From: Sarah Sutcliffe <[REDACTED]>
Sent: 04 April 2022 09:45
To: Simon Davis
Subject: RE: AL/28/22/DOC (Condition 10) & AL/29/22/DOC (Condition 11) (Wing's Nursery, Lidsey Road)

Condition 11:

Condition 10:

Engineers Comments Regarding Condition 10

ATTENUATION BASIN

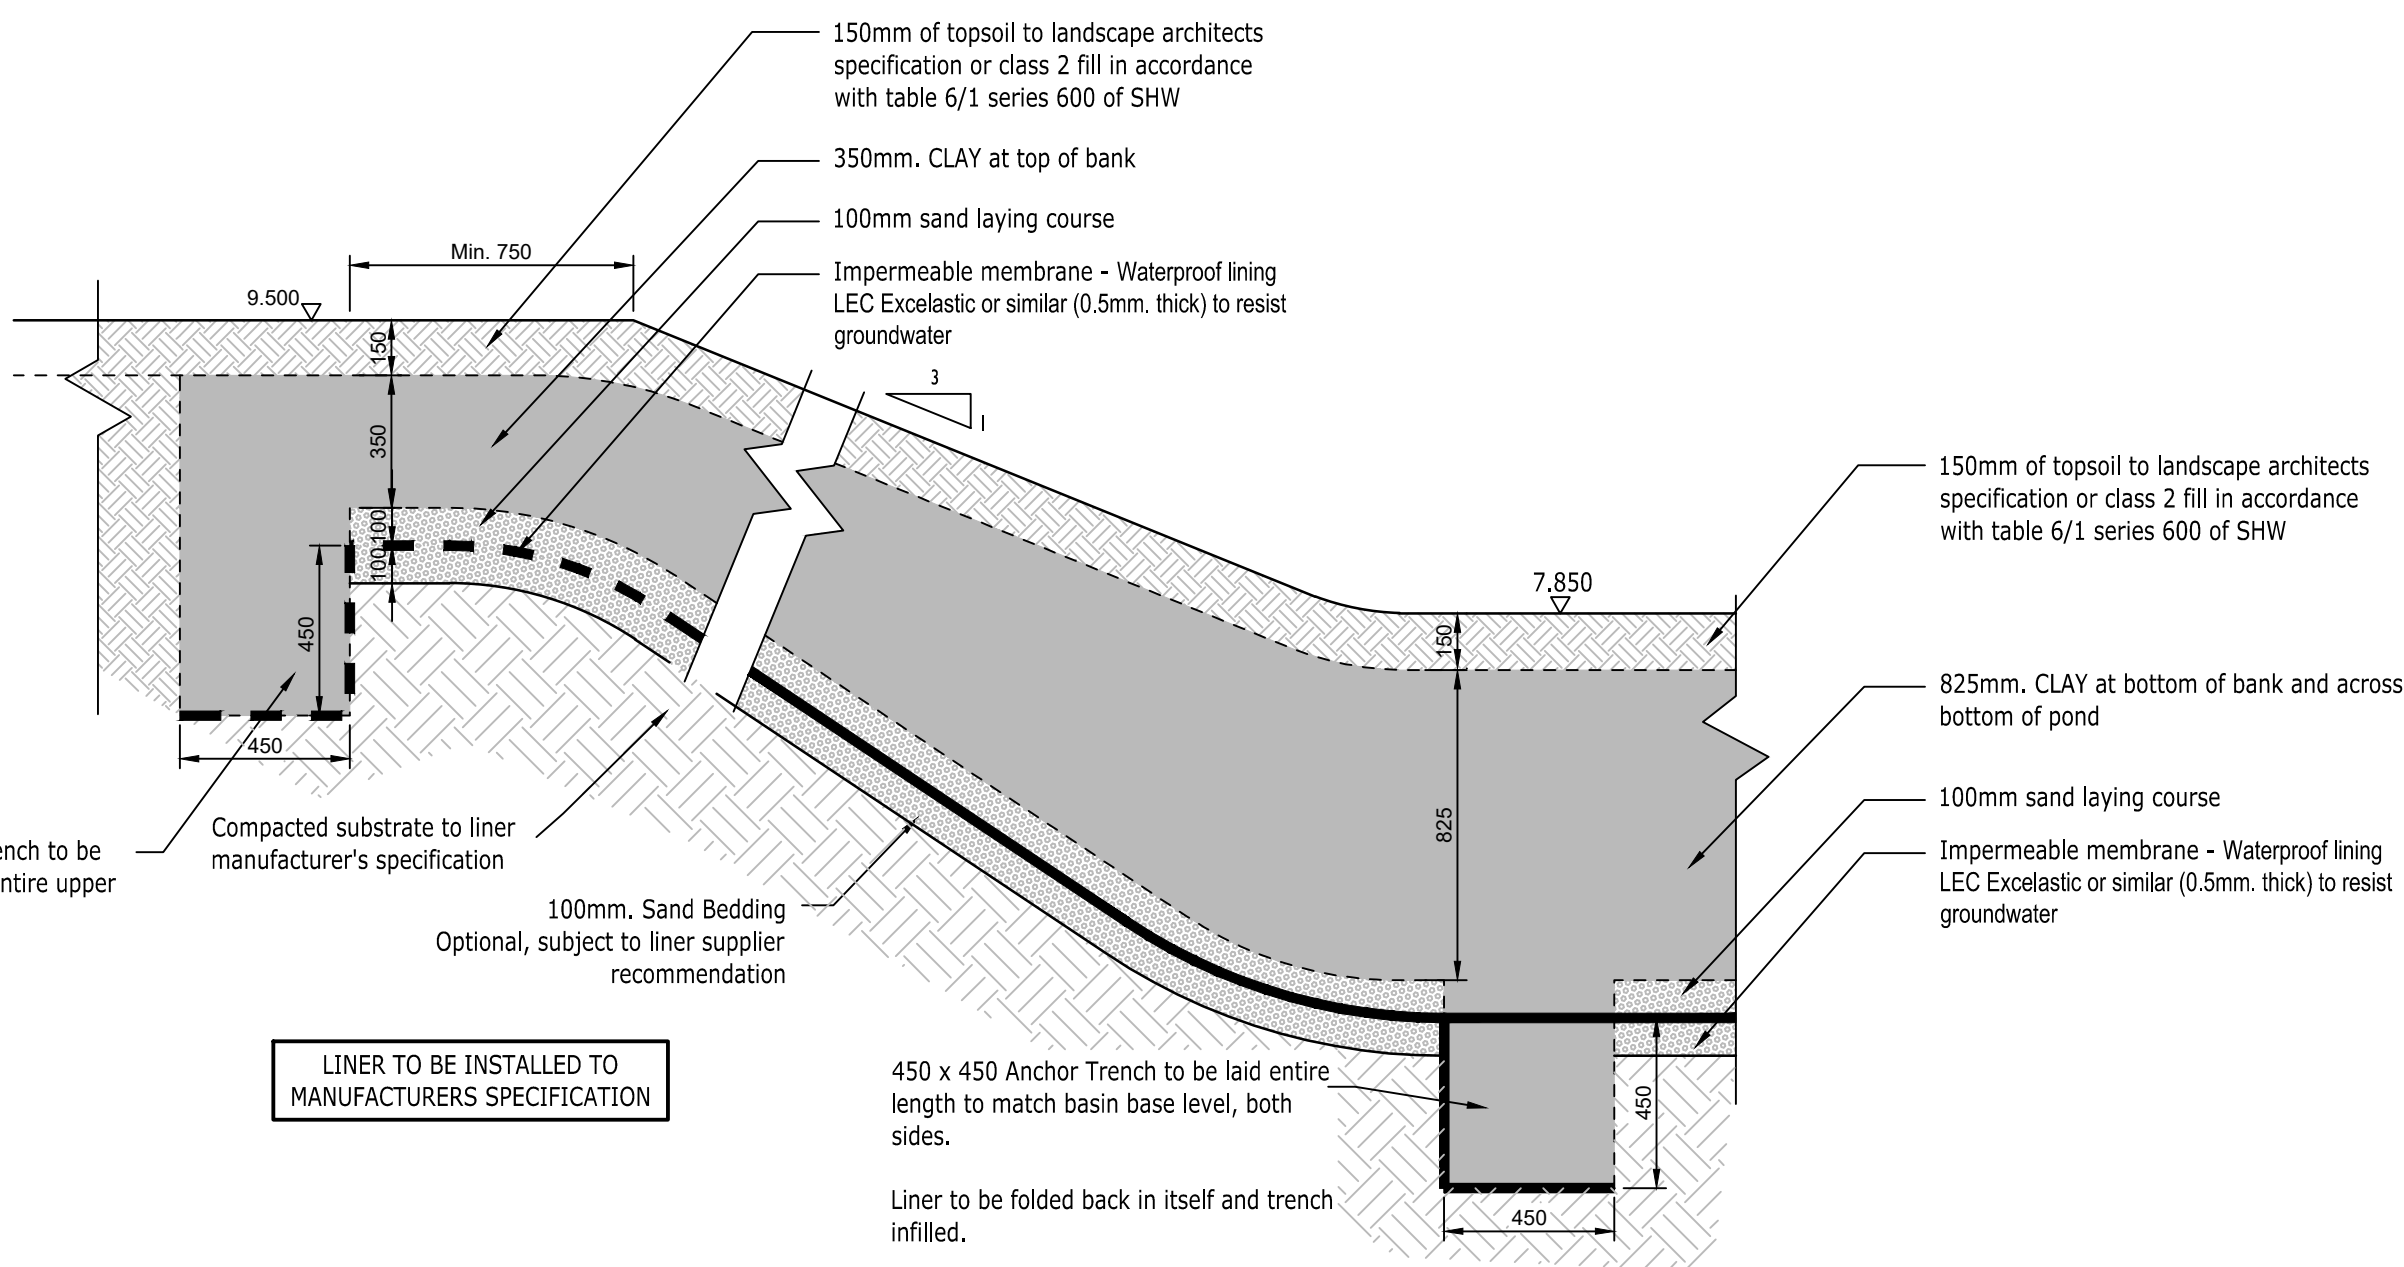
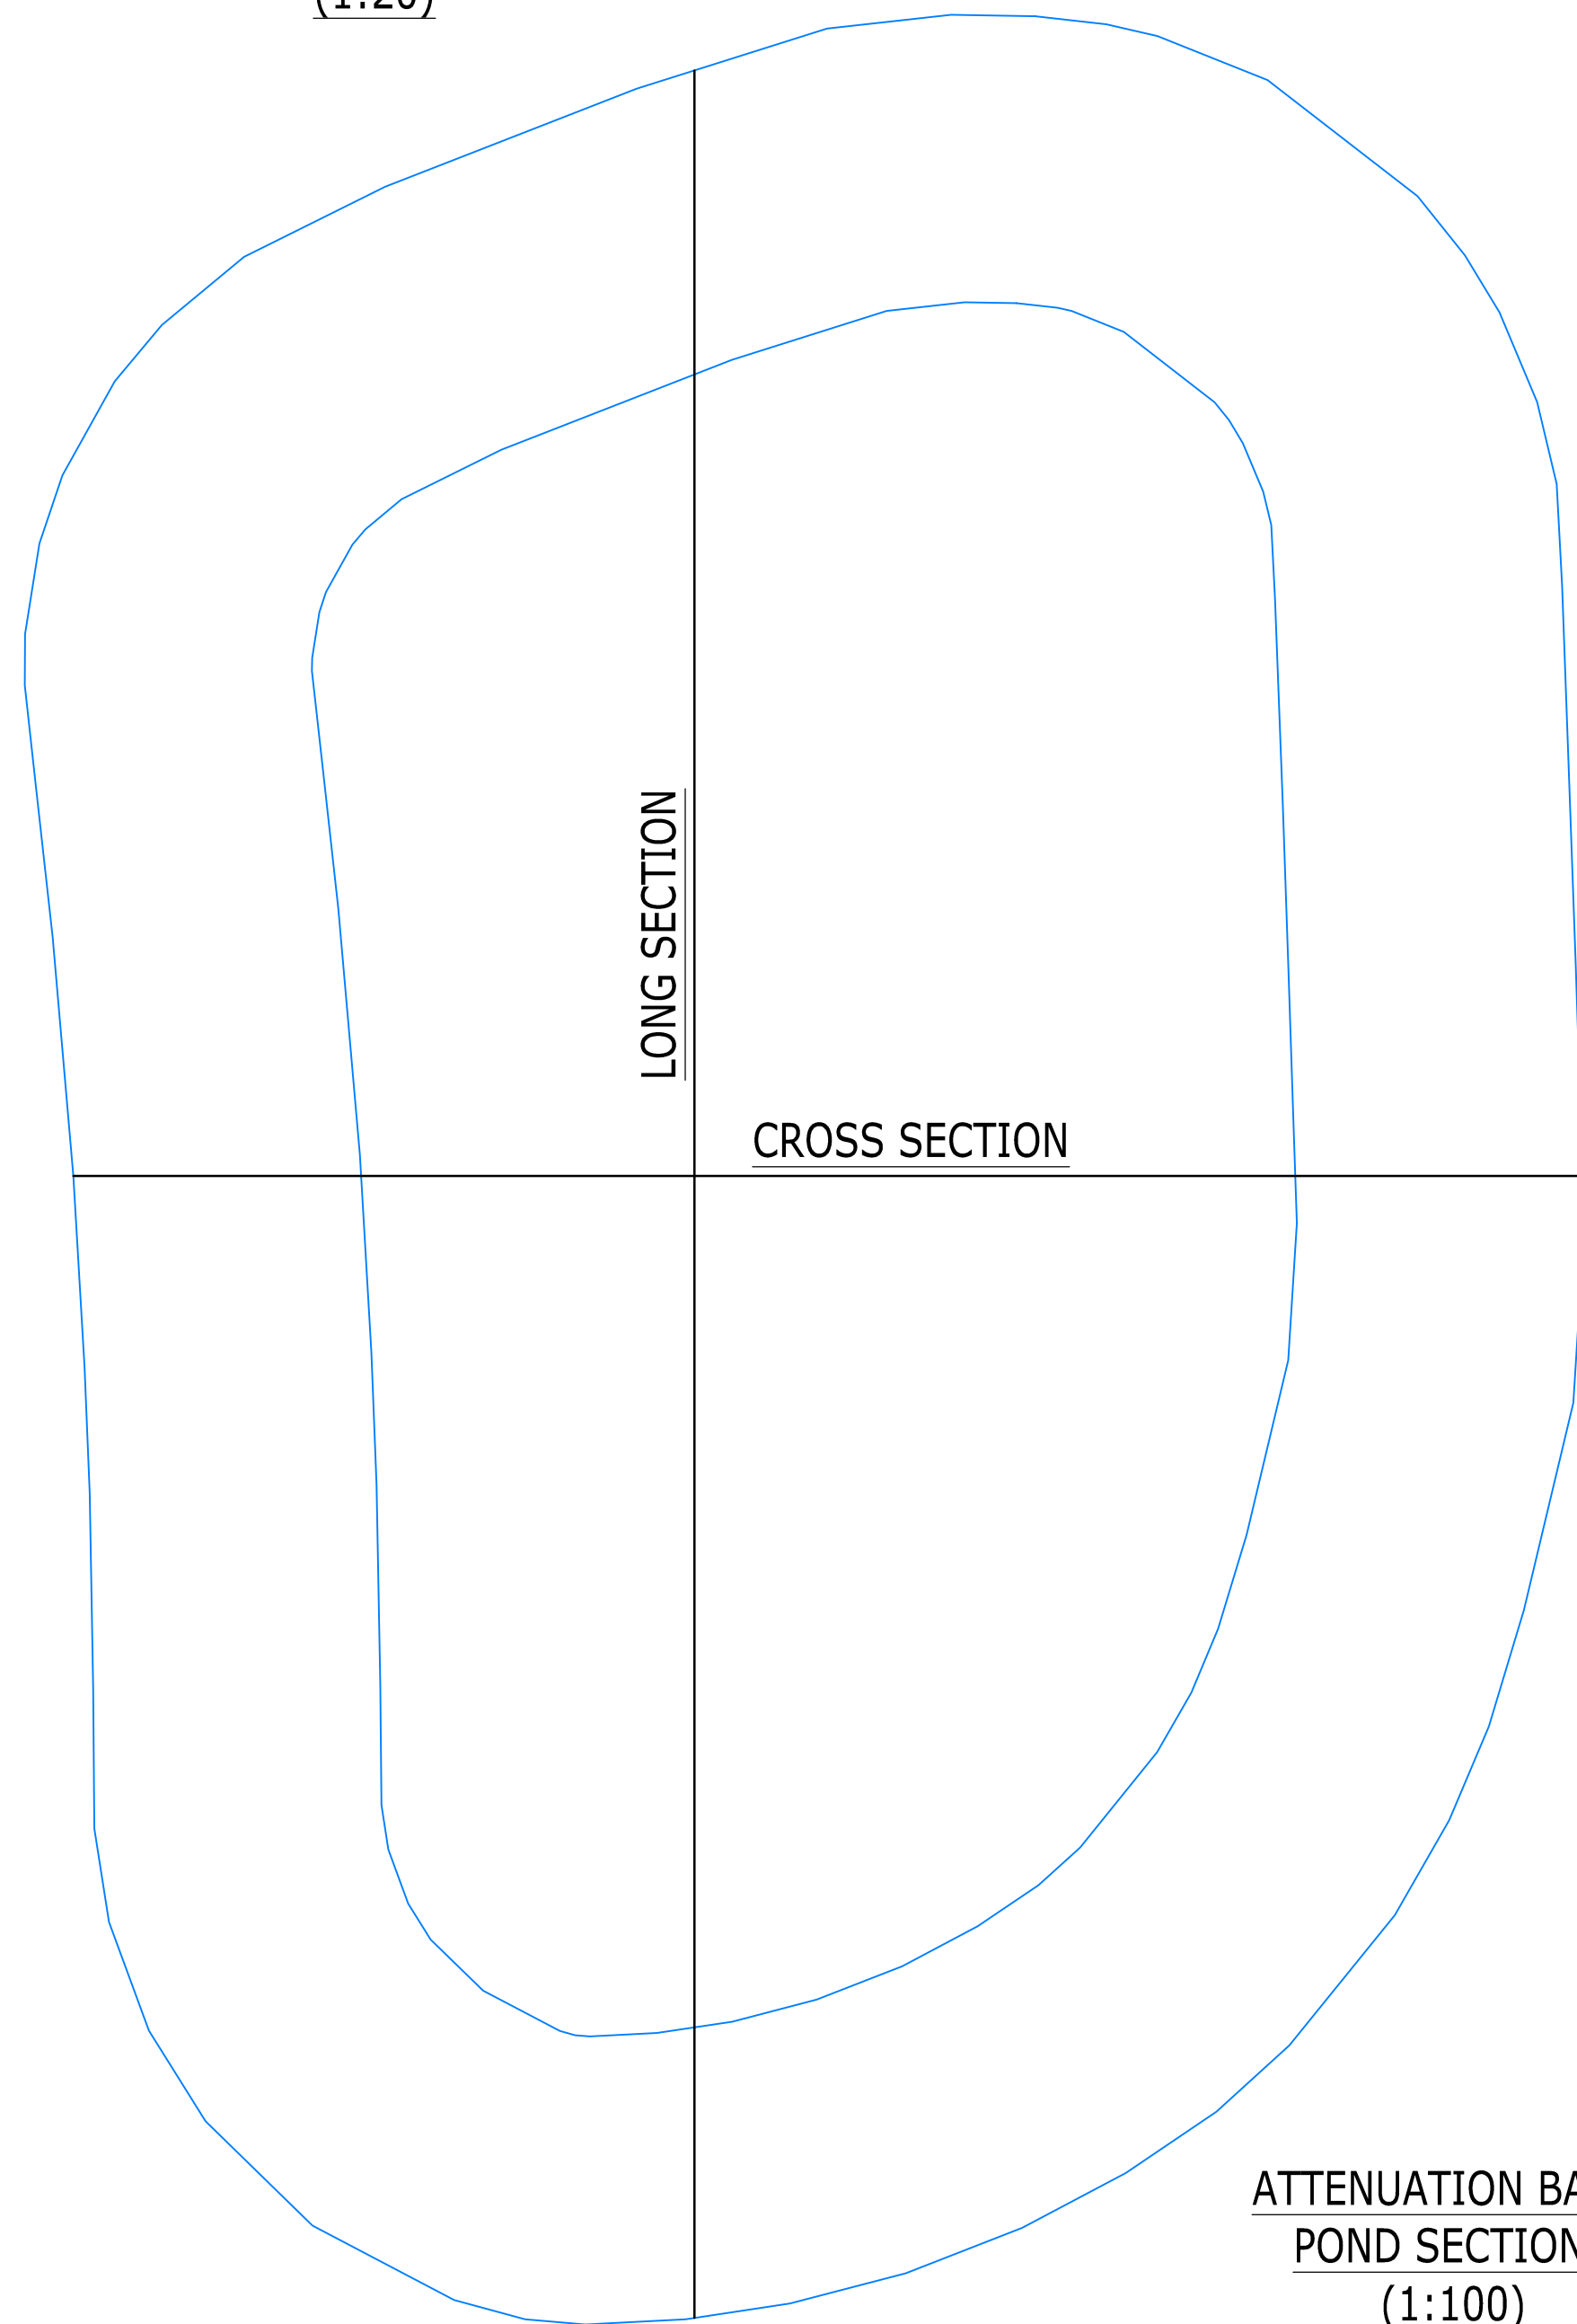
16. *Please provide construction detail drawings of permeable paving. The construction detail is now updated.*
17. *Please provide two perpendicular cross sections of the basin, please detail liner, topsoil depths, etc. on construction detail drawing. Please refer to drawing 15.3.*

FLOW CONTROL CHAMBER S23

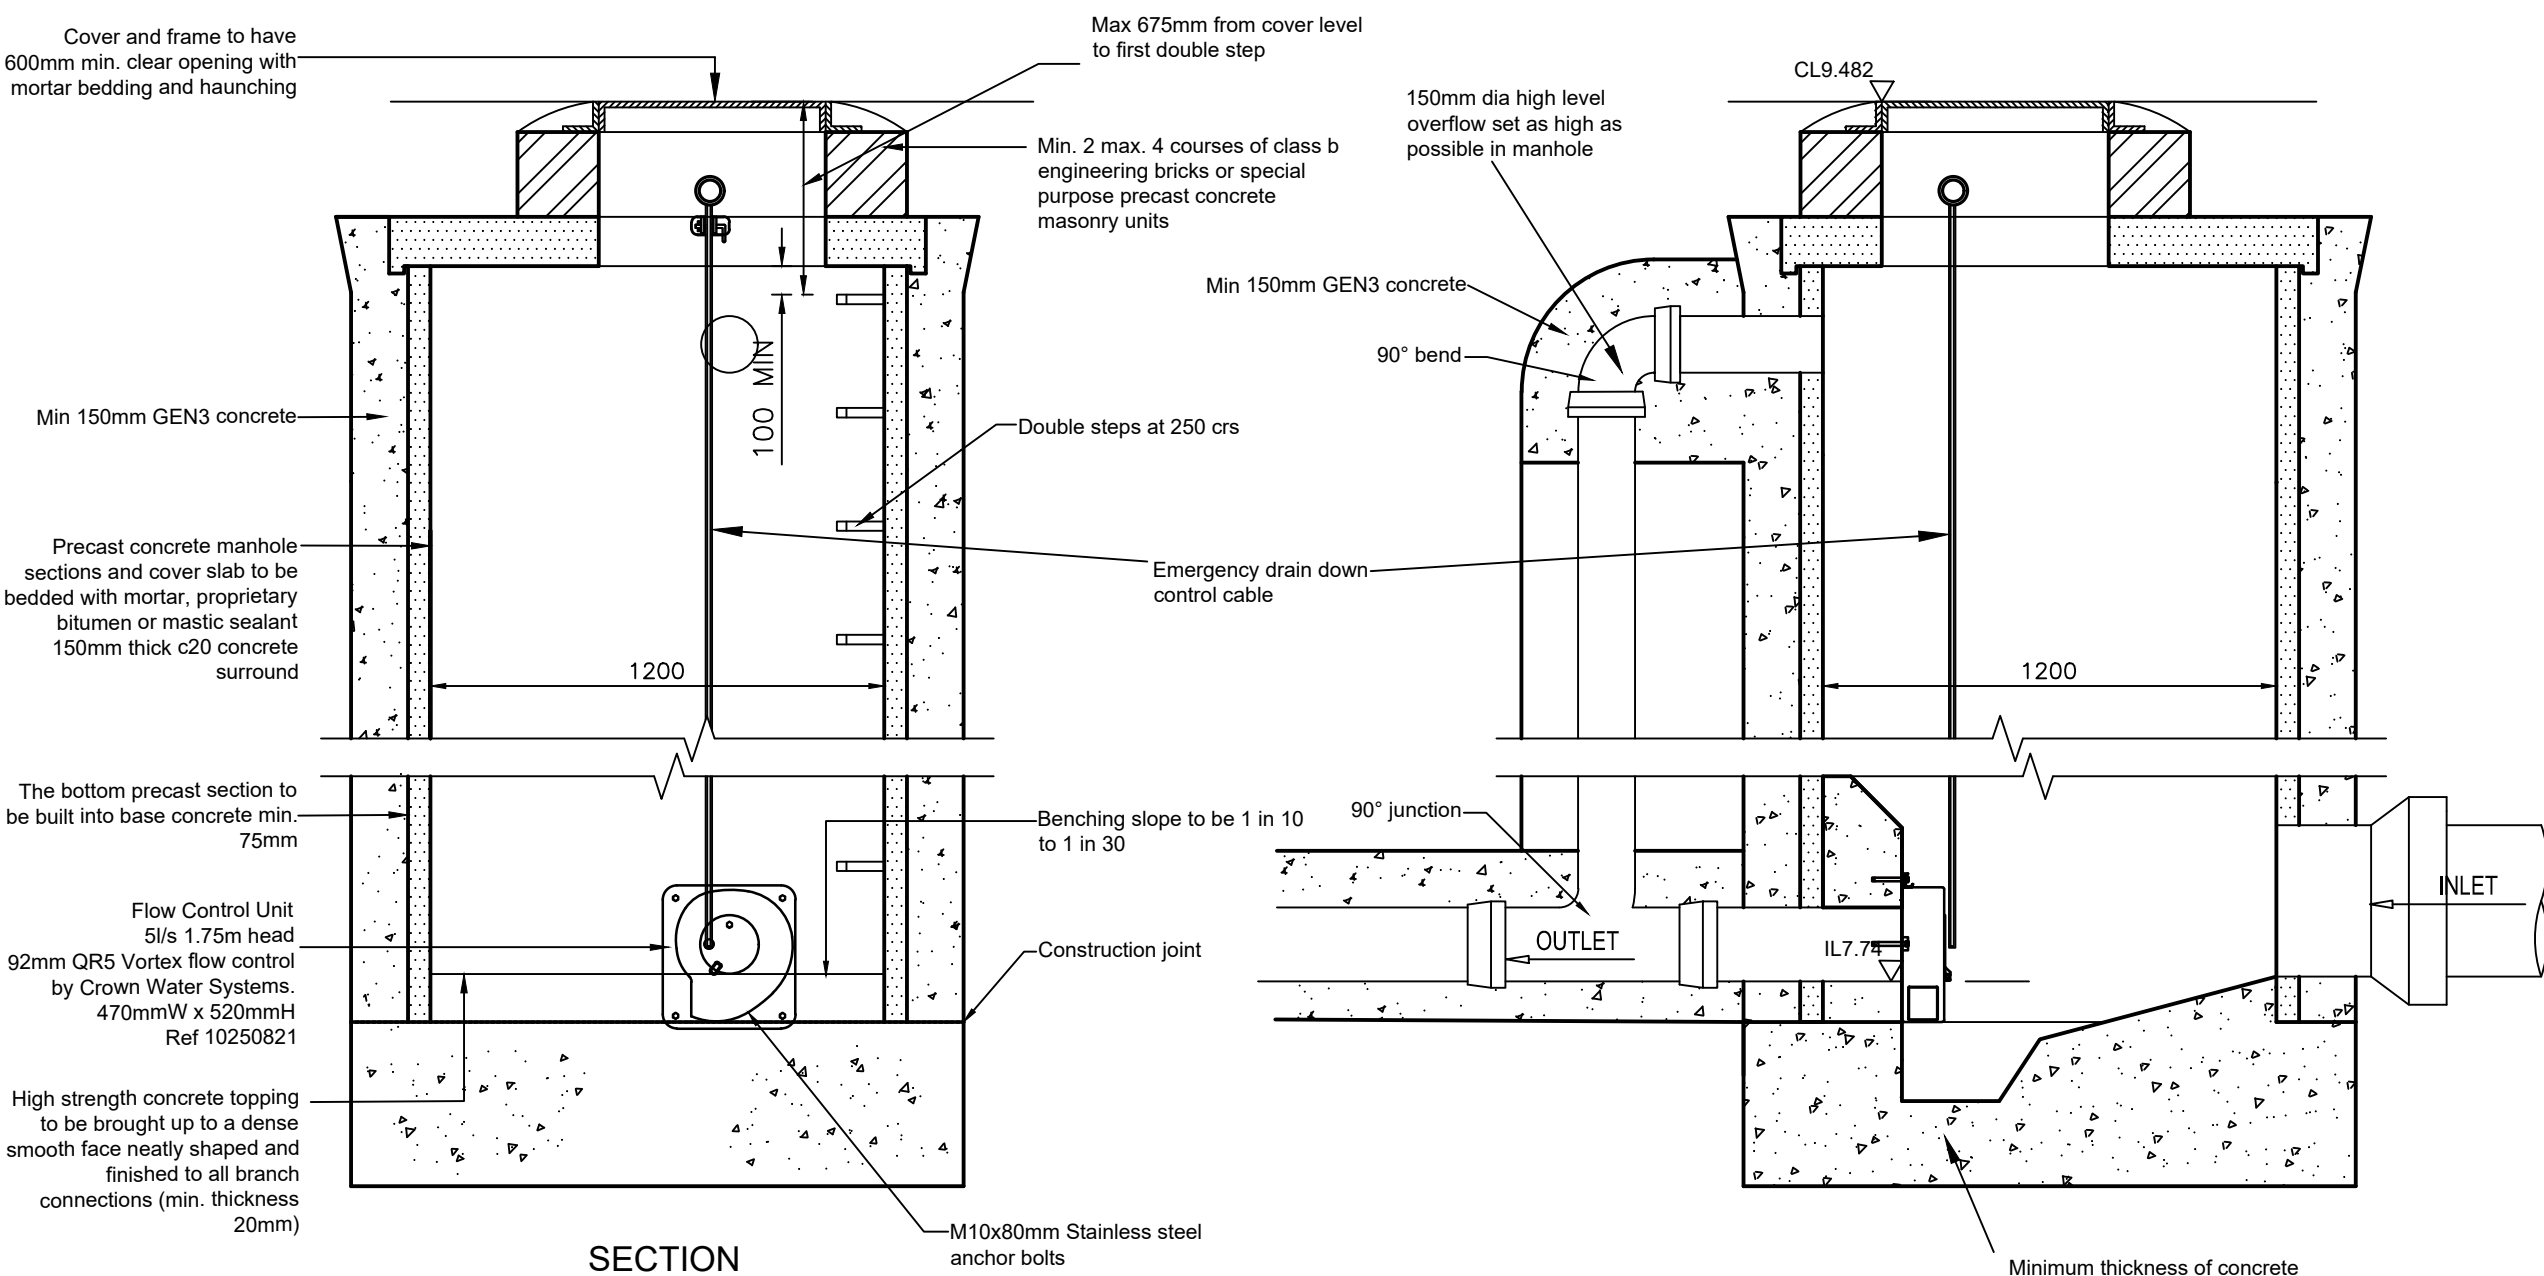
14. *Please detail overflow level on S23 construction detail drawing. The construction detail now specifies the overflow location and size.*
15. *Please detail membrane around attenuation tank on construction detail drawing. Please make detail site specific. The construction detail is now updated.*
